CDS is requesting comments on the following short plat application: SP-24-00013 McIntosh.

SP-24-00013

TO: All Staff
FROM: Public Works Plan Review Team
DATE: October 17, 2024
SUBJECT: SP-24-00013 McIntosh

McINTOSH SHORT PLAT PART OF SECTION 8, T. 18 N., R. 18 E., W.M. KITTITAS COUNTY, WASHINGTON

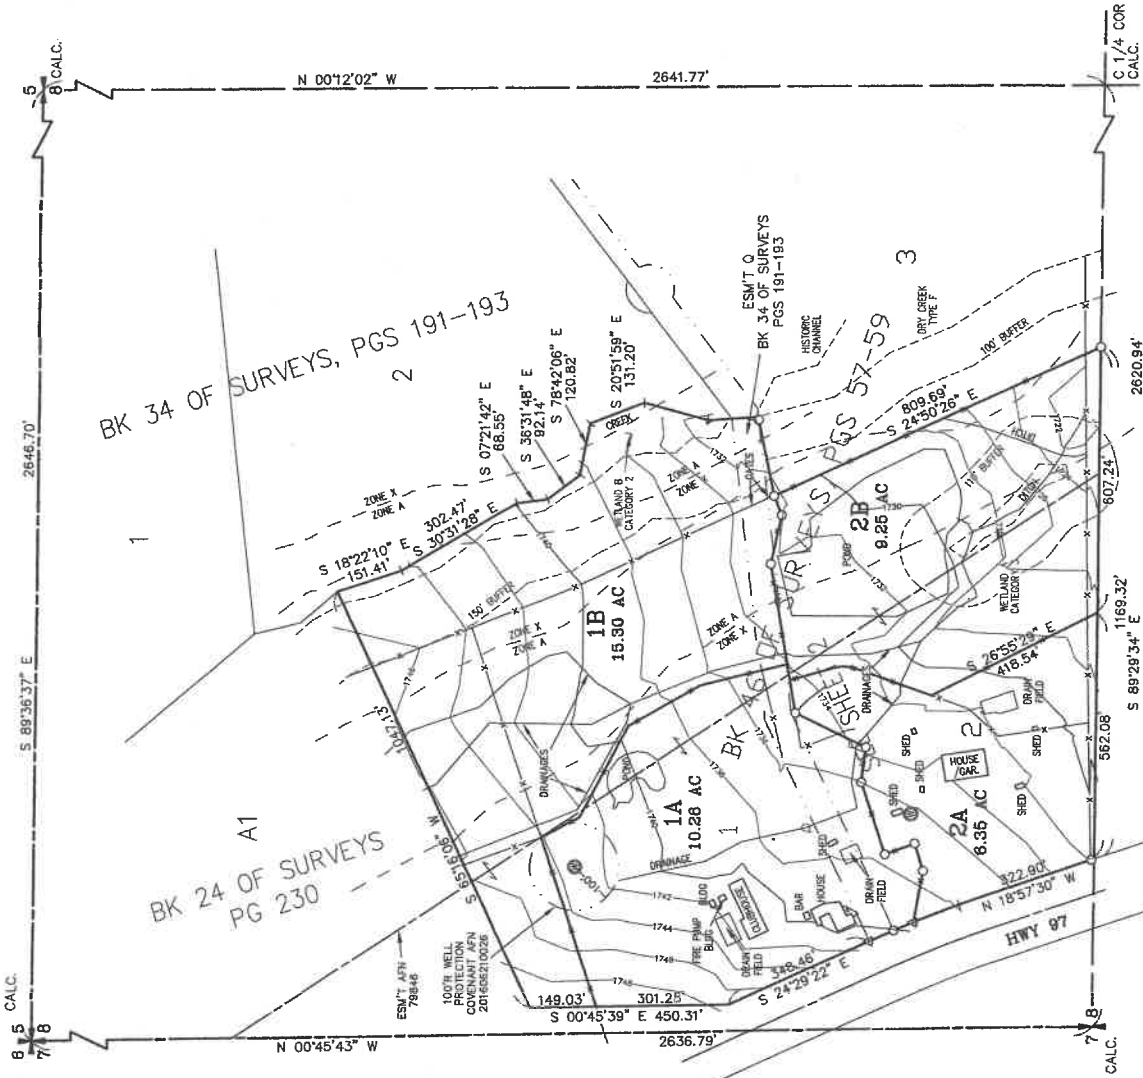
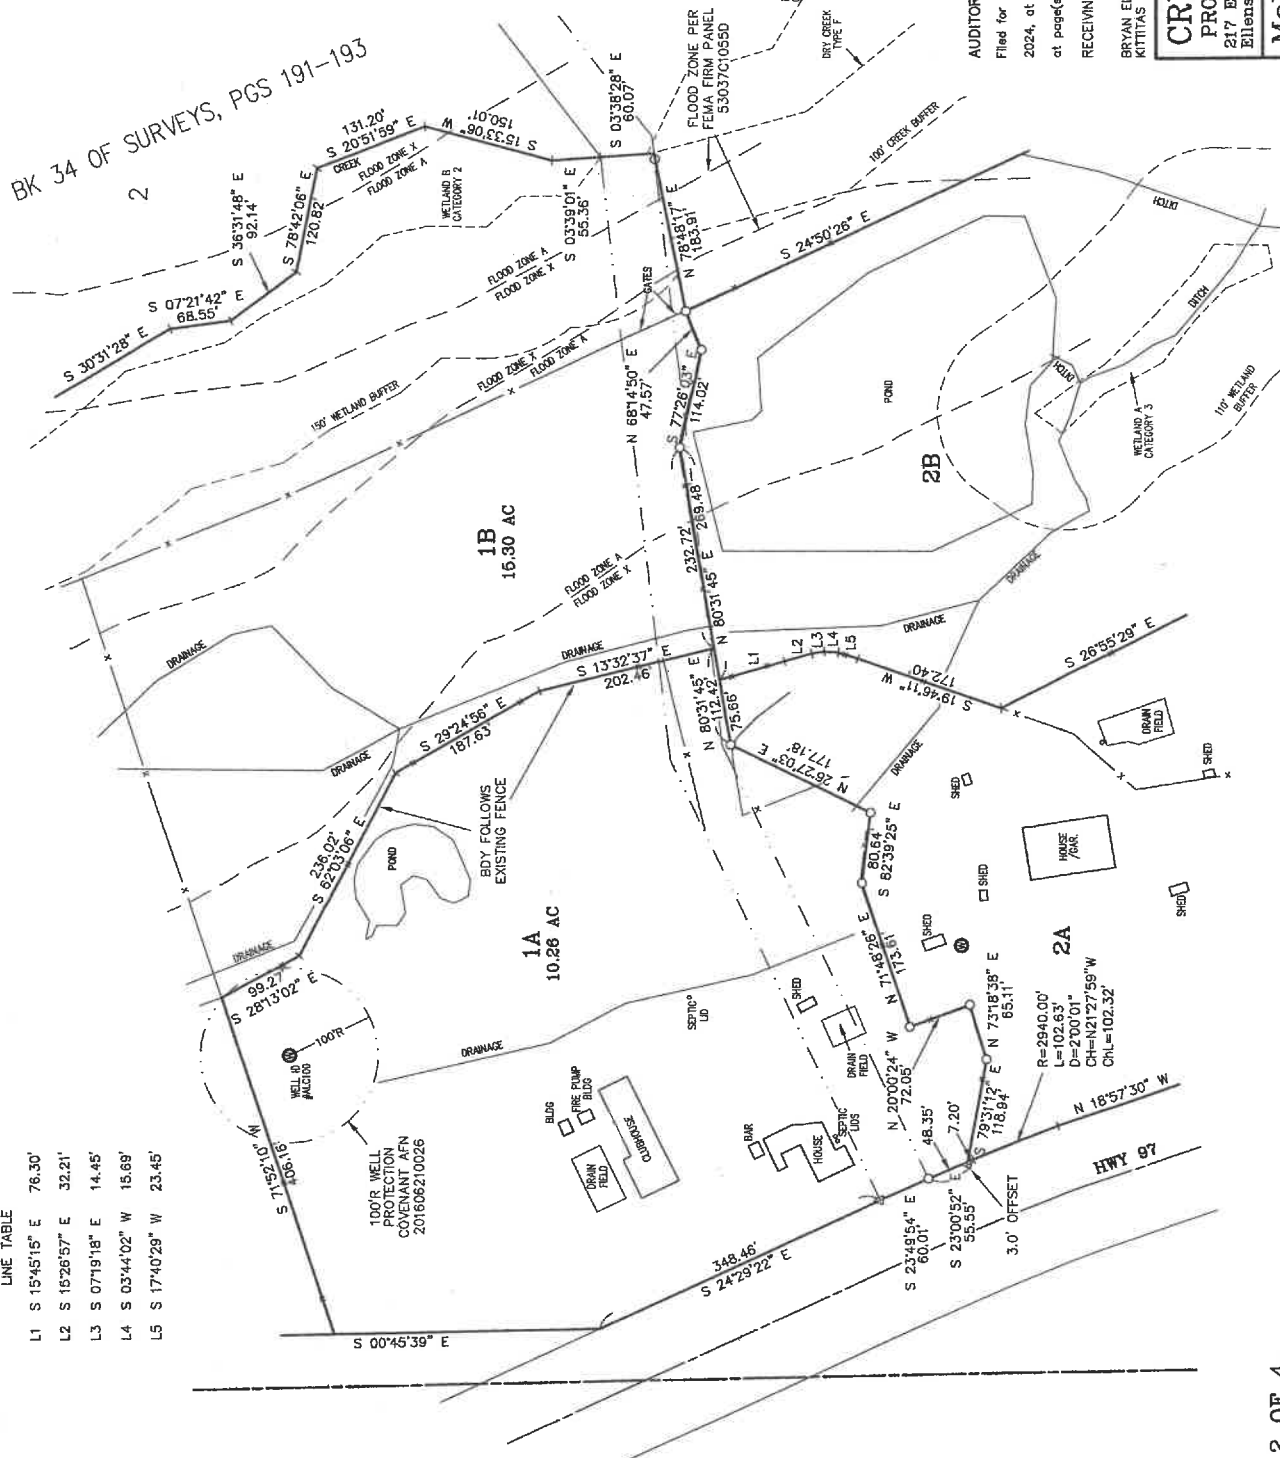
ACCESS	<ol style="list-style-type: none">1. An approved access permit shall be required from the Kittitas County Department of Public Works prior to creating any new driveway access or altering an existing access.2. KCC allows up to 4 lots on a joint-use driveway. Additional lots utilizing easement Q may trigger private road standards and requirements (road naming and road certification).3. An access permit from WSDOT may be required.4. Maintenance of driveway approaches shall be the responsibility of the owner whose property they serve. The County will not maintain accesses.5. Any further subdivision or lots to be served by proposed access may result in further access requirements. See Kittitas County Road Standards.6. In addition to the above-mentioned conditions, all applicable Kittitas County Road Standards apply to this proposal. Access is not guaranteed to any existing or created parcel on this application. <p>OF NOTE: Easement Q has a drain field and shed located in access easement. Relocation of easement Q may be required. (JS)</p>

SURVEY	Verify equipment used. Page one says GPS for contours, page 3 calls out a total station. Missing basis of bearings. SR97 needs to call out ownership and ROW width. Width for existing easement needs added. Missing Point of beginning of deed. Currently, there are 3 access driveways to proposed lot 2A. Not shown on existing survey (DF)
TRANSPORTATION CONCURRENCY	No transportation requirement for this project. (KAH)
FLOOD	<p>A portion of parcels #15102 and 866033 are within the FEMA identified special flood hazard area (100-year floodplain) zone A. If possible, any future development should occur outside of the floodplain in order to reduce risk and avoid mandatory flood insurance purchase requirements. All activities within the floodplain must be permitted through the floodplain development permit process and follow the regulations within KCC 14.08.</p> <p>In accordance with KCC Chapter 14.08.220, all subdivisions as well as new development shall:</p> <ol style="list-style-type: none">1. Be consistent with the need to minimize flood damage.2. Have public utilities and facilities such as sewer, gas, electrical, and water systems located and constructed to minimize flood damage.3. Have adequate drainage provided to reduce exposure to flood damage.4. Where base flood elevation data has not been provided or is not available from another authoritative source, it shall be generated for subdivision proposals and other proposed developments containing greater than 50 lots or 5 acres (whichever is lesser) and shall be included as part of the application and shall be noted on the final mylar.5. All subdivisions shall show on the face of both the preliminary and final plat, for either short or long plats, the boundary of the 100-year floodplain and floodway. <p>Since the parcels are located in zone A, KCC 14.08.220(4) is applicable. Please contact the Floodplain Administrator at 509-962-7523 for assistance. (SC)</p>
